WEST SUSSEX COUNTY COUNCIL CONSULTATION

TO:	Arun District Council FAO: Raymond Cole
FROM:	WSCC - Highways Authority
DATE:	15 December 2020
LOCATION:	Land West of New Barn Lane, Bersted, PO21 5DN
SUBJECT:	BE/119/20/PL 1 No. detached house. This site falls within Strategic Site SP2, CIL Zone 1 (Zero Rated).
DATE OF SITE VISIT:	N/A
RECOMMENDATION:	Advice
S106 CONTRIBUTION TOTAL:	N/A

- Roof - Grey flat tile
- Brick - Buff

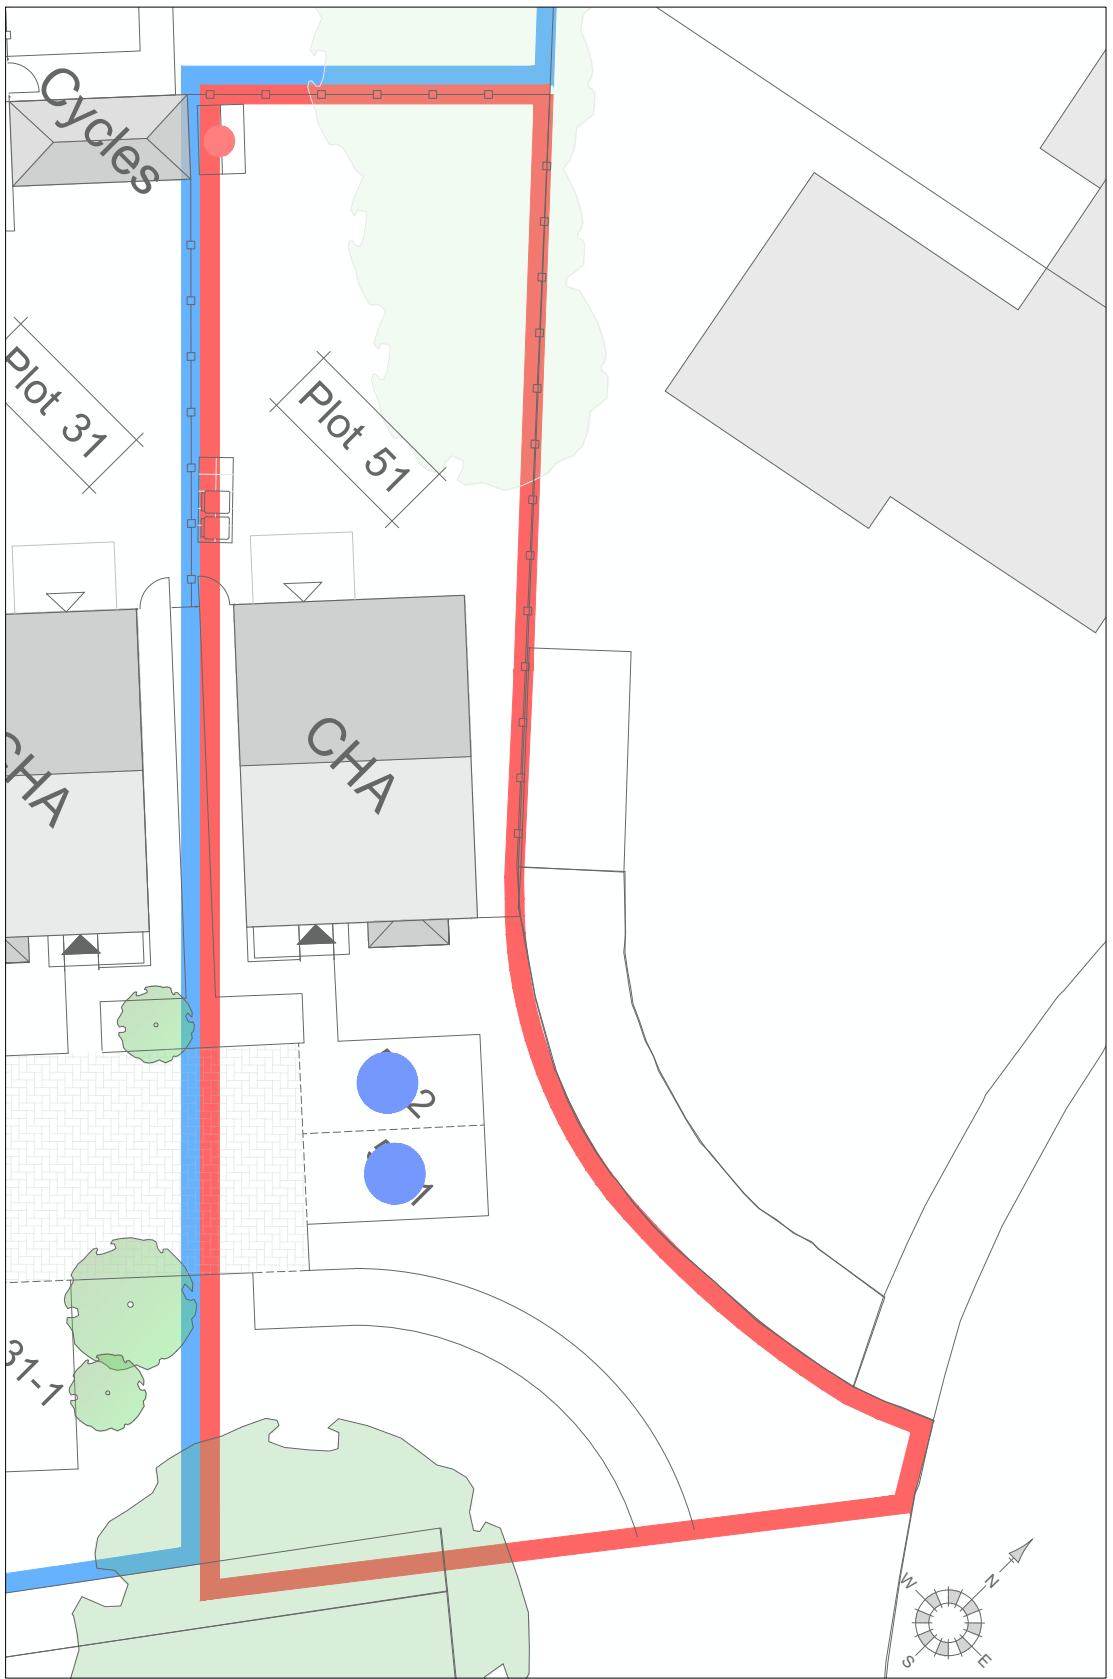
The applicant proposes a vehicular access at the end of Herdwick Lane. It is unclear if any works are proposed to cater for the two parking spaces. If the applicant does propose any access works, the LHA advises the applicant to consult the proprietor of the unadopted road to obtain formal approval for such works.

The applicant proposes two car parking spaces for this development. Under Arun Parking Standards (adopted January 2020), the LHA would anticipate that two car parking spaces would be sufficient for a dwelling of this size and location.

The LHA does note that on-site turning does not appear achievable. As such, cars leaving the site may have to perform a turn in the road in order to exit the development in a forward gear. However, given the sites location, this is not anticipated to result in a severe highway safety concern.

Regarding cycle parking, the applicant proposes a cycle store to the rear of the plot, with provision for two cycles. This is in accordance with WSCC parking standards for a dwelling of this size. The inclusion of secure and covered cycle parking helps promote the use of sustainable transport methods.

No part of the development shall be first occupied until the car parking has been constructed in accordance with the approved site plan. These spaces shall thereafter be retained at all times for their designated purpose.

No part of the development shall be first occupied until covered and secure cycle parking spaces have been provided in accordance with plans and details to be submitted to and approved by the Local Planning Authority.
